Appeal Decision

Appeal Ref: 6001306

The Old Dairy, Whitewell Road, Cow Ark, Whitewell, Lancashire BB7 3DG

- The appeal is made under section 78 of the Town and Country Planning Act 1990 (as amended) against a refusal to grant planning permission.
 - The appeal is made by Dr Alexander Bonner against the decision of Ribble Valley Borough Council.
 - The application Ref is 3/2025/0362.
 - The development proposed is described on the application form as “Two-storey side extension. Modification of an existing window opening to form a new front entrance door. Installation of solar panels and air source heat pump.”
-

PROPOSED FLOOR PLANS

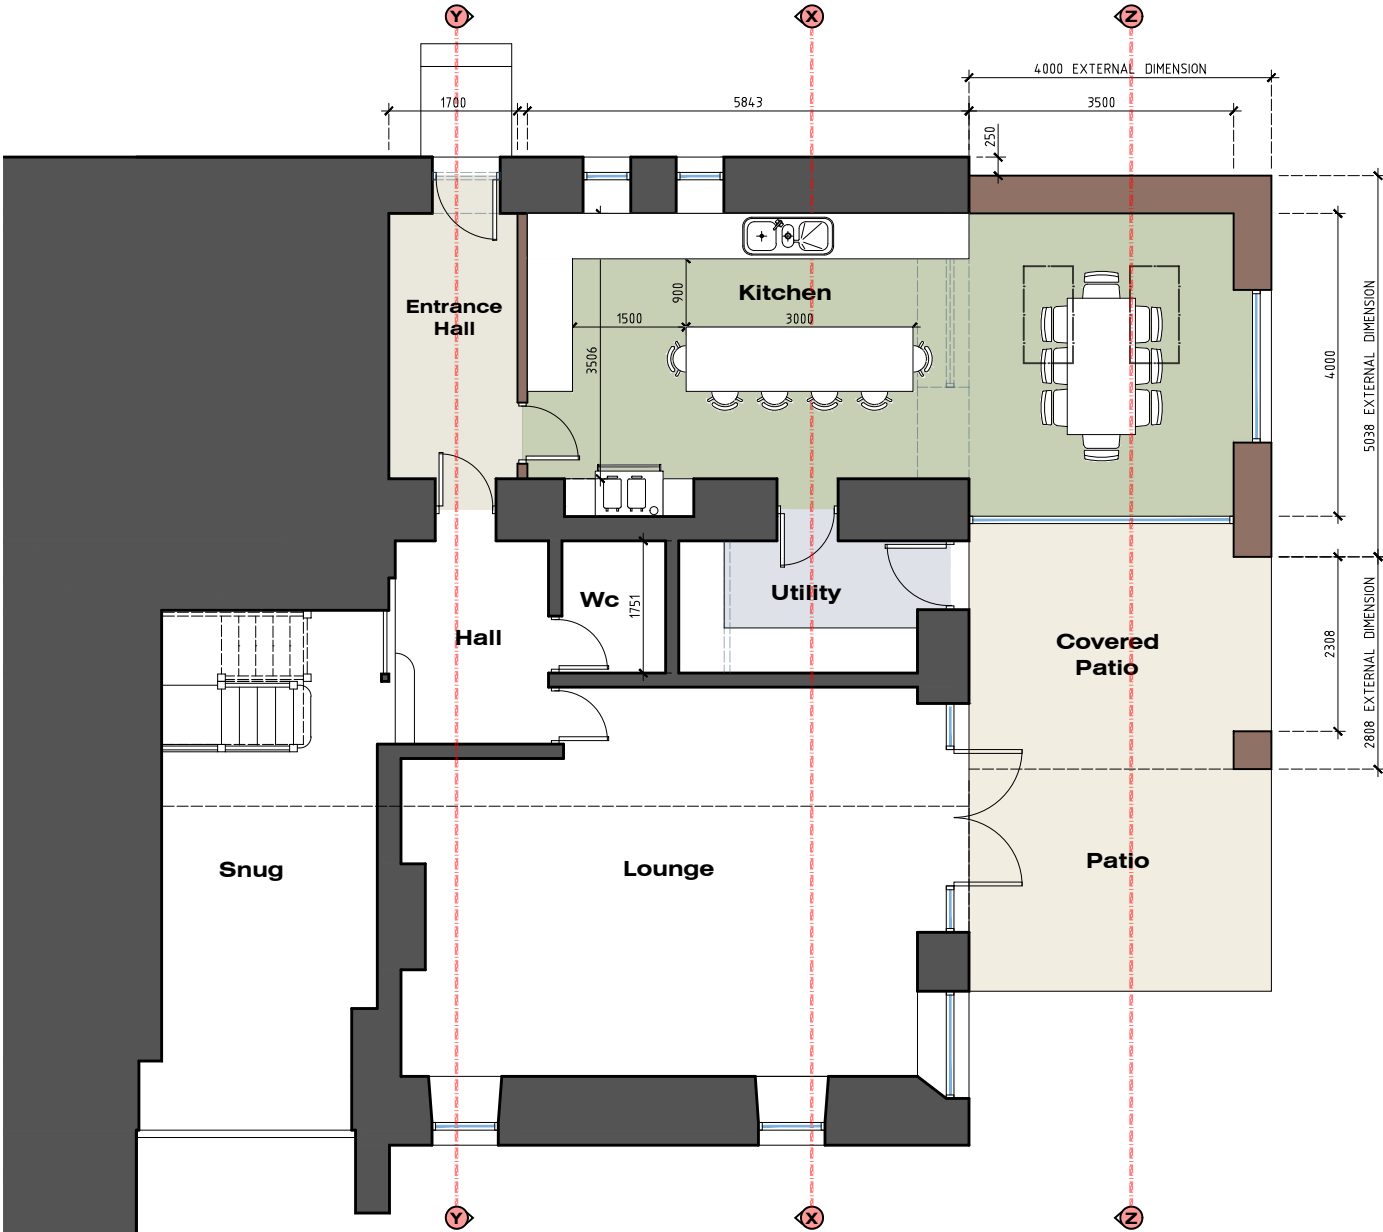
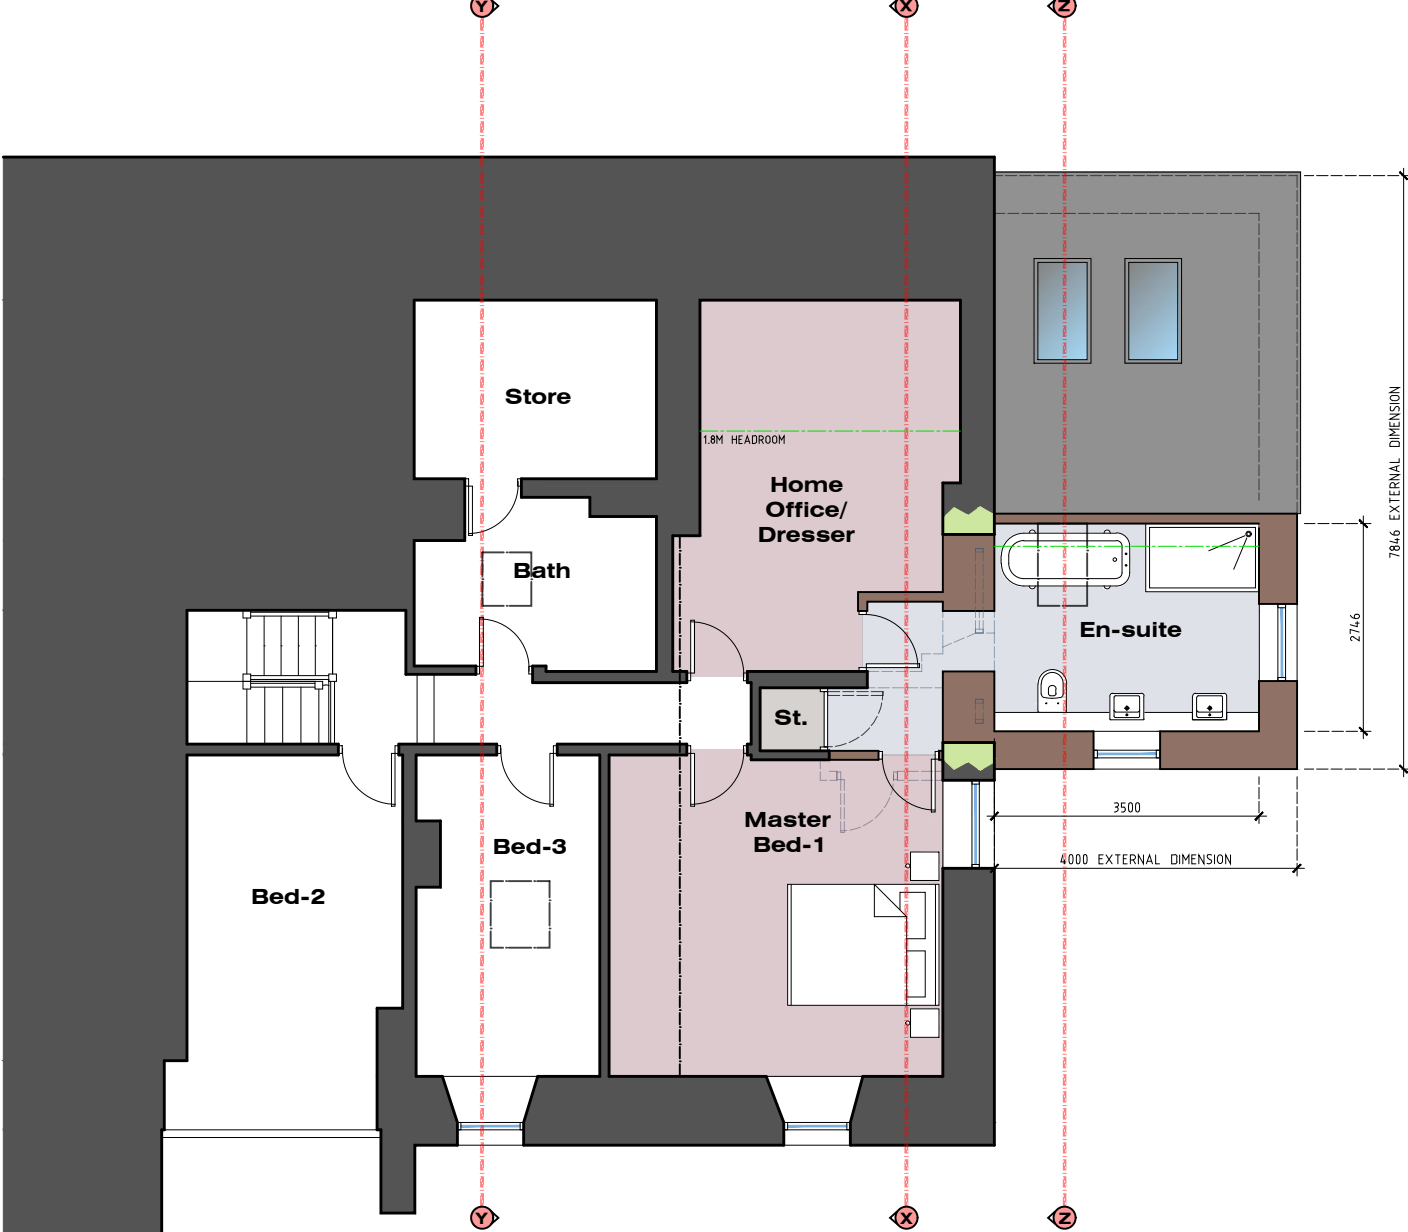
7. The proposed development would include a 2- storey extension to the side of the appeal property. Although the use of stone and slate to the external walls and roof would reflect the materials of the existing building, the roof configuration would not respect its design or proportions or those of the wider group. The ridge would be offset from that of the original building, resulting in a comparatively short rear roof slope, at odds with the proportions of the existing building, giving the rear elevation a somewhat squat appearance. This sizeable addition of a structure of different proportions would complicate the appearance of the building, at odds with its simple character. As a result, the extension would appear visually jarring and discordant in relation to the proportions and simple form of the existing building.

8. The overhang to the proposed covered terrace and the large openings would further exacerbate the extension's incongruous appearance, introducing features not typically found on traditional agricultural buildings, including within this group. These elements would detract from the simple agricultural form and vernacular character of the wider group. Moreover, the number of openings proposed in the extension's front roof slope, concentrated within a relatively small area, would detract from the distinctive expansive and predominantly unbroken roof slope, to the detriment of its traditional agricultural character.
